Applicant: Albion Land

Proposal: Discharge of condition 13 (landscaping) of 21/03177/F

DATE: 22 November 2023

Status
FOR INFORMATION S2
Drawing number
0897-RFM-XX-00-DR-L-0005 Revision
P06

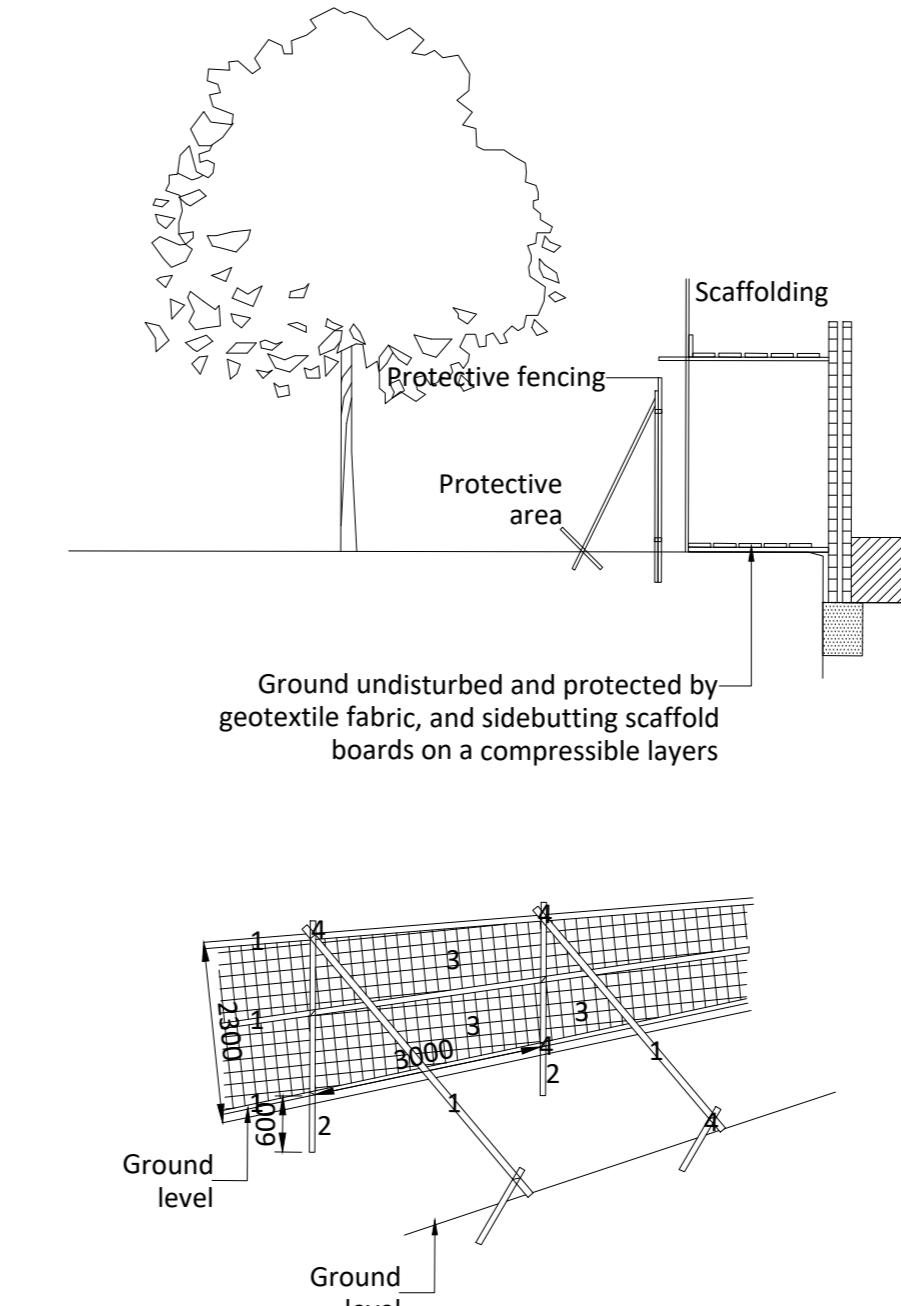
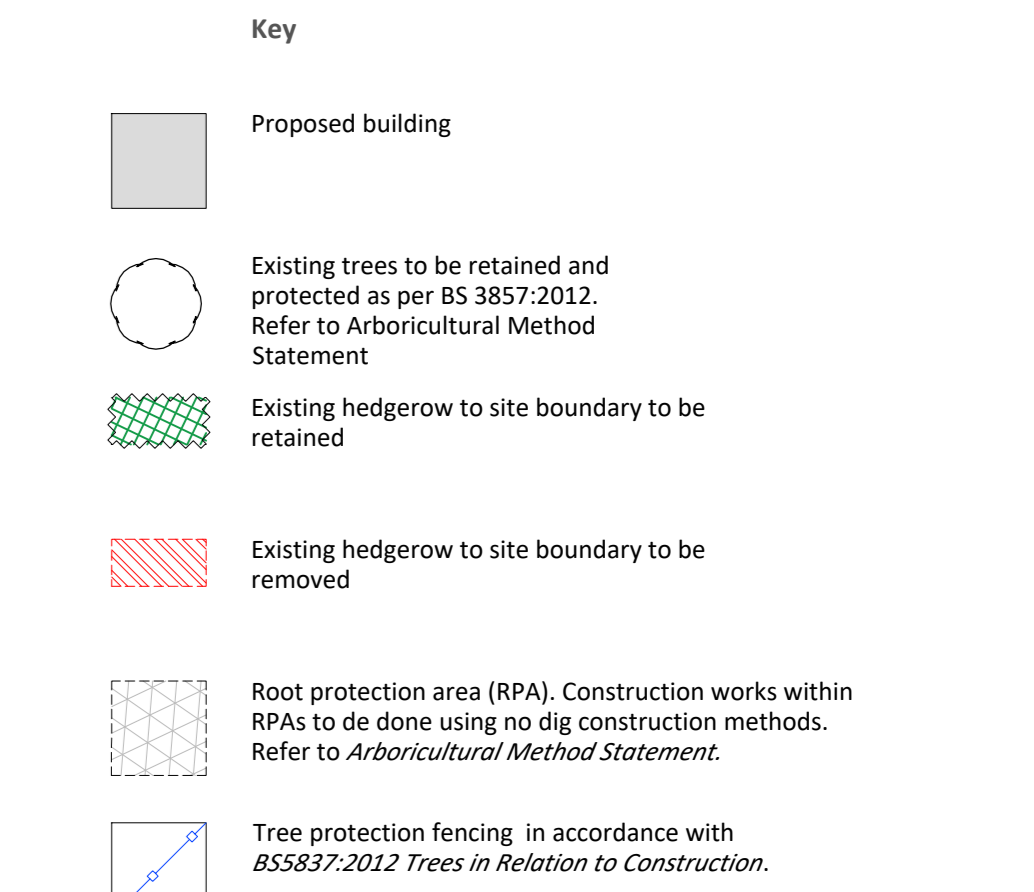
- 5.1. CDC Landscape – If the northern boundary is planted in the locations for trees indicated (refer to enclosed drawing), and the landscape planting plan amended to accord with this then I am happy for the condition to be discharged.

I confirm that I am pleased to accept the additional 2 no. *Fagus sylvatica* (Standard) and 3 no. *Quercus robur* (Standard) on the northern boundary, as indicated on the Detailed Planting Plan Drawing No. 0897-RFM-XX-00-DR-L-0004. The trees are positioned correctly and allow enough space to avoid the future road.
